WEST SUSSEX COUNTY COUNCIL CONSULTATION

TO:	Arun District Council FAO:Simon Davis
FROM:	WSCC - Highways Authority
DATE:	6 October 2021
LOCATION:	Land at Unit 4 Hawthorn Road Hawthorn Road Littlehampton BN17 7LT
SUBJECT:	LU/263/21/PL Construction of a two-storey office building (Use Class E). This application is in CIL Zone 2 (zero rated) as other development.
DATE OF SITE VISIT:	n/a
RECOMMENDATION:	No Objection
S106 CONTRIBUTION TOTAL:	n/a

No.	Description	Date
Client:	Chico & Mash	
Address:	Unit 4 Hawthorn Road, Littlehampton.	
Project:	Proposed Office Building	
Drawing title:	Block Plan	
Project No	18107	
Date	20-12-19	
Drawn by	IA	
Drawing No	BP01	
Scale1:500@A3

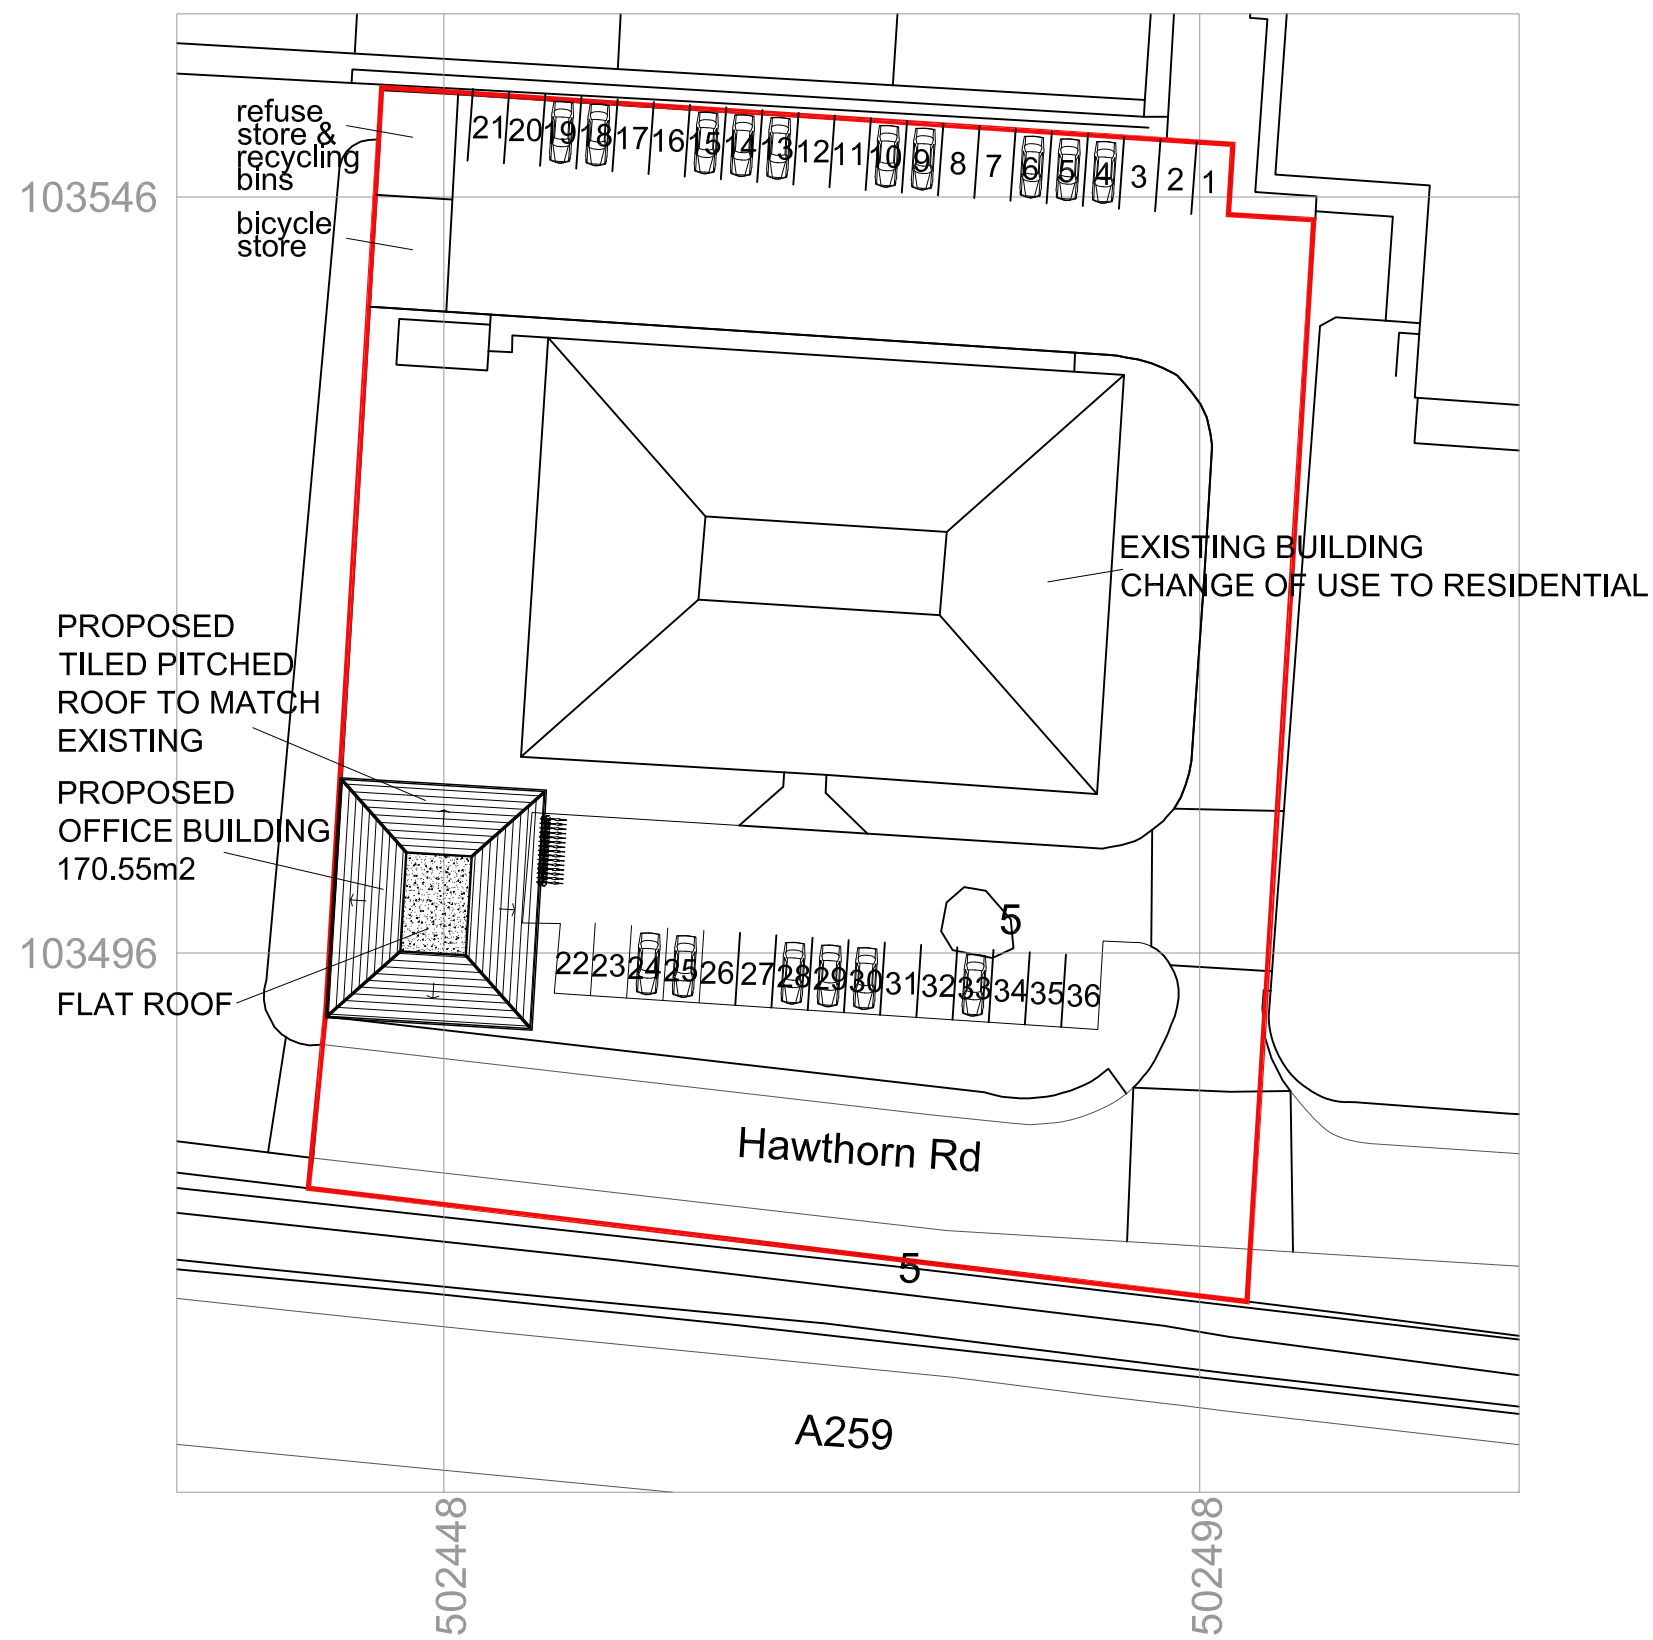
The approach to parking is in principle accepted with it recognised that peak demands for residential and office uses occur at different times. Having all parking as unallocated therefore increases the flexibility in terms of how the spaces can be used.

The submitted transport note does consider potential parking requirements for the already permitted residential units against the WSCC Parking Demand Calculator rather than the Arun DC Parking Standards. The Planning Authority may wish to request the transport note is updated to refer to the appropriate standards. Nevertheless, as the transport note implies, additional parking can occur within the site. Overspill parking could occur along Hawthorn Road although this is unadopted and any controls on parking would be privately managed.

No part of the development shall be first occupied until the car parking has been constructed in accordance with the approved site plan. These spaces shall thereafter be retained at all times for their designated purpose.
